City of Portland, Maine - Building or Use Permit Application

Location of Construction: 155 HARTLEY ST	Owner Name: HALL RICHARD D	Owner Address: 153 HARTLEY ST	PERMIT ISSUED <div style="border: 1px solid black; padding: 5px; display: inline-block;"> JUL 12 2006 </div>
Business Name:	Contractor Name: Home owner	Contractor Address:	
Lessee/Buyer's Name	Phone:	Permit Type: Alterations - Dwellings	Zone: RS
Past Use: Single Family	Proposed Use: Single Family 12' x 24.5' deck	Permit Fee: \$50.00	Cost of Work: \$3,000.00
Proposed Project Description: 12' x 24.5' deck 23.5'		INSPECTION: Use Group: 23 Type: SB 7/11/06 Signature: <i>[Signature]</i>	
		PEDESTRIAN ACTIVITIES DISTRICT (P.A.D.) Action <input type="checkbox"/> Approved <input type="checkbox"/> Approved w/Conditions <input type="checkbox"/> Denied Signature: _____ Date: _____

Proposed Use: Single Family 12' x 24.5' deck	Proposed Project Description: 12' x 24.5' deck
--	--

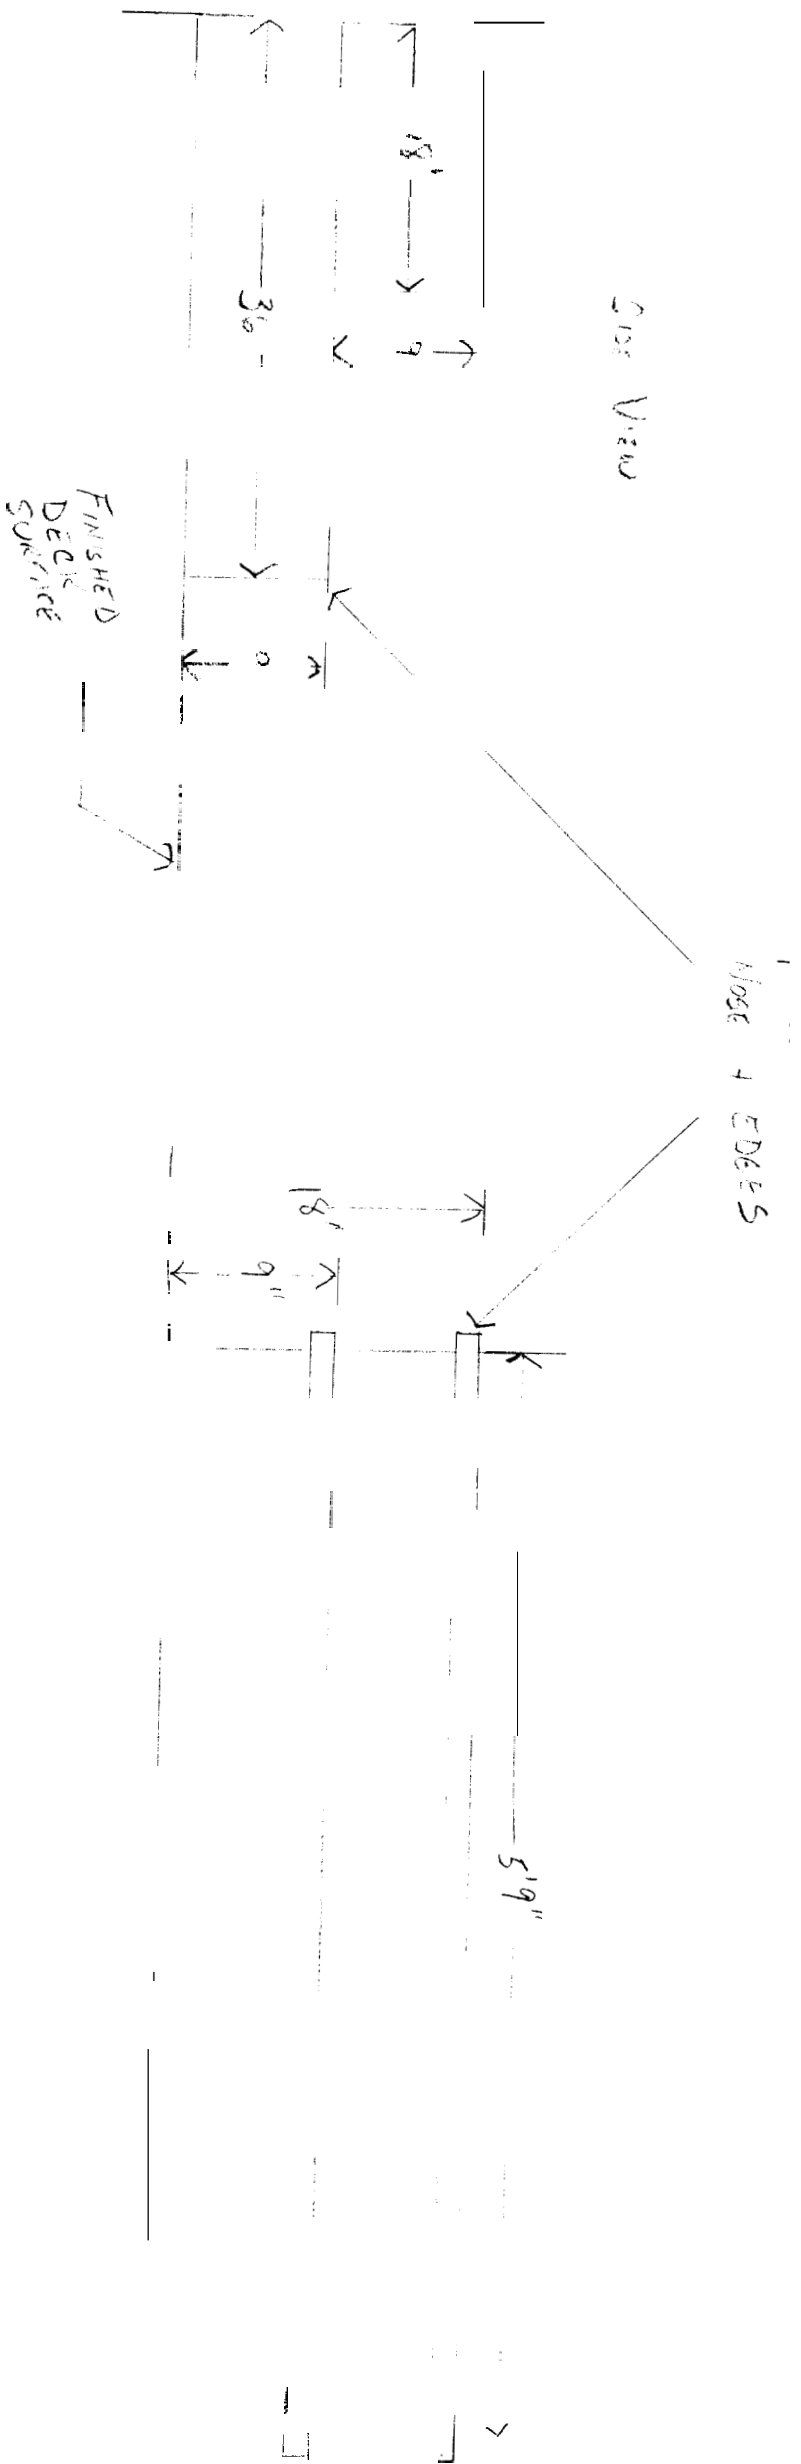
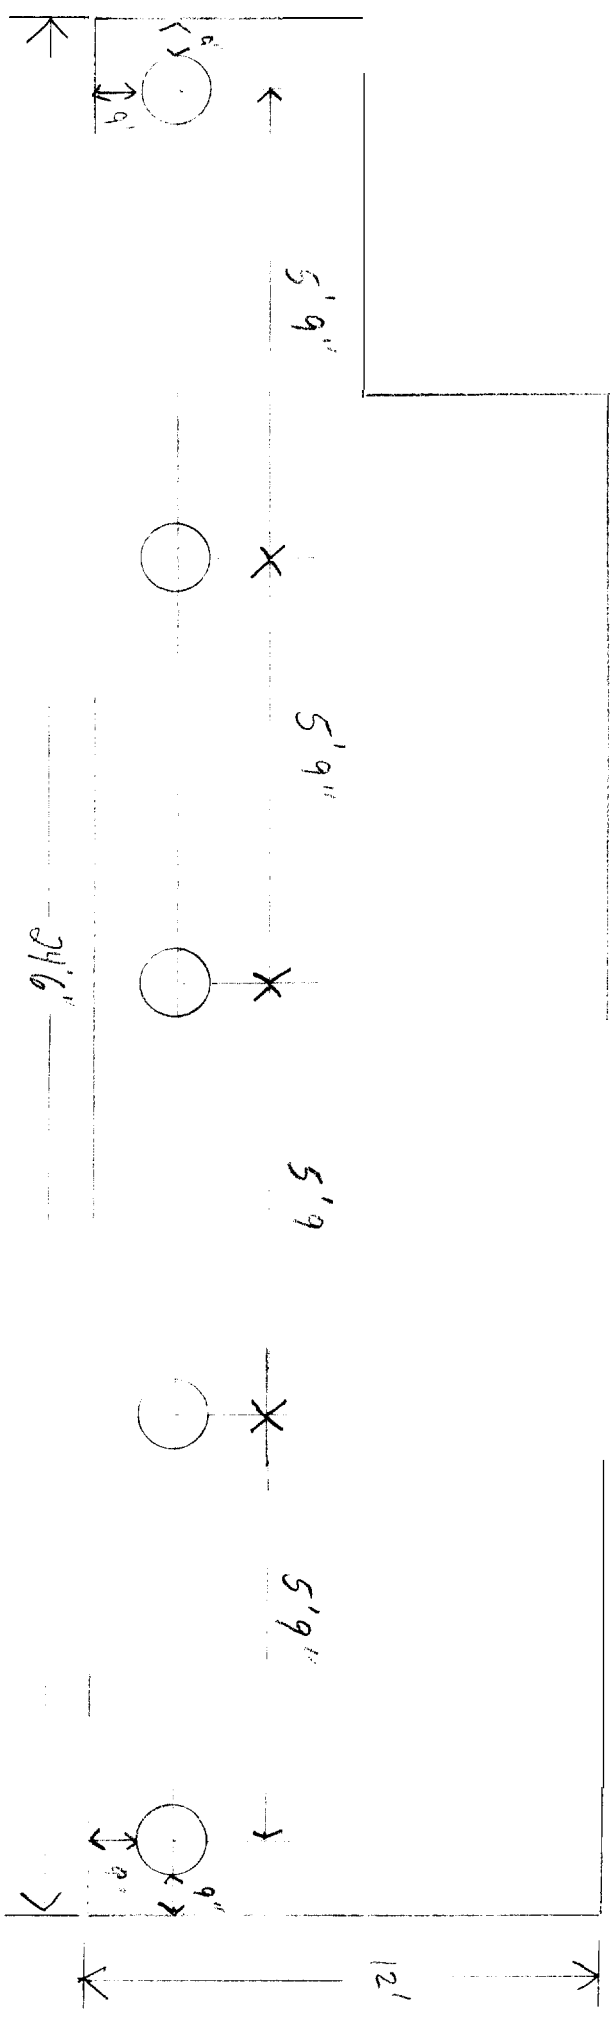
Note: Proposed deck did not meet rear setback. The plot plan said 19'4" and the required setback is 20'. Richard Hall sent a fax stating that he would reduce the deck to 23'6" in order to meet the rear setback. **Ok to Issue:**

FOUNDATION SYSTEM

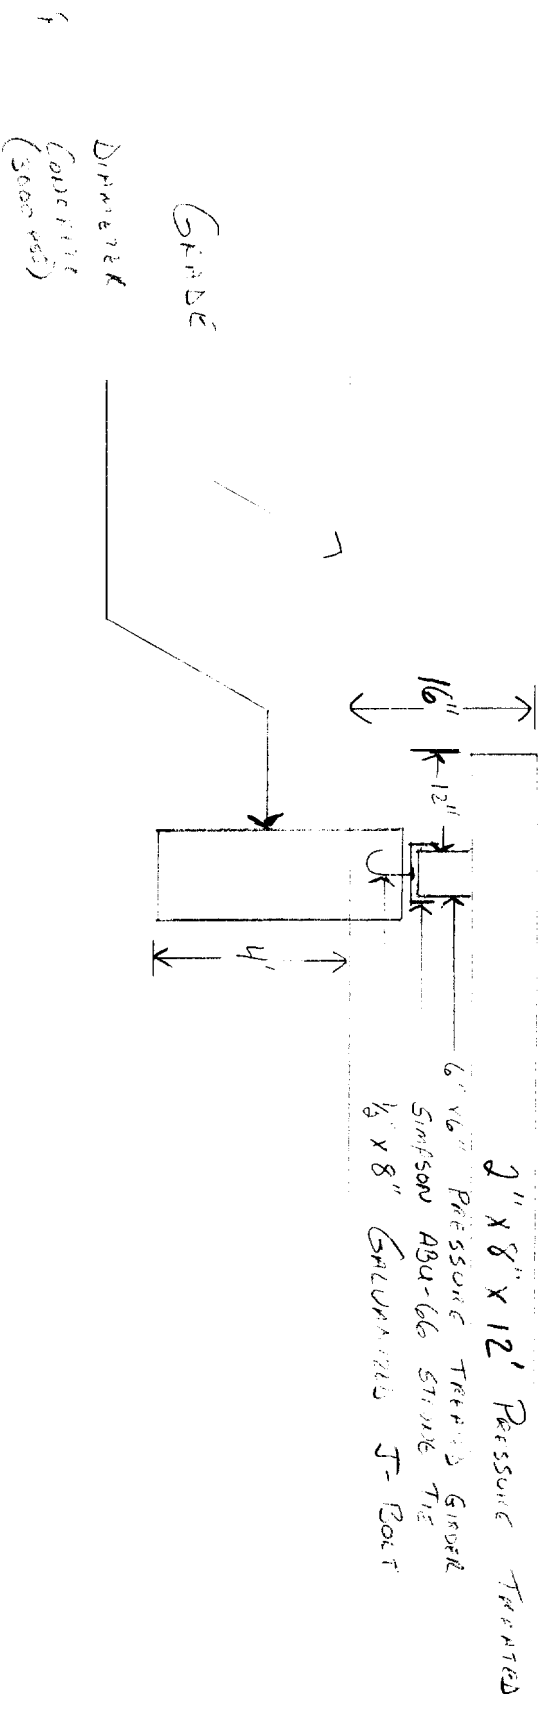
- 1) The Girder must be two (2) 2" x 8" members based on the spans presented.

The risers cannot exceed 7 3/4 inches (9 Inches shown!)
Owner notified and agreed to these conditions 7/11/06
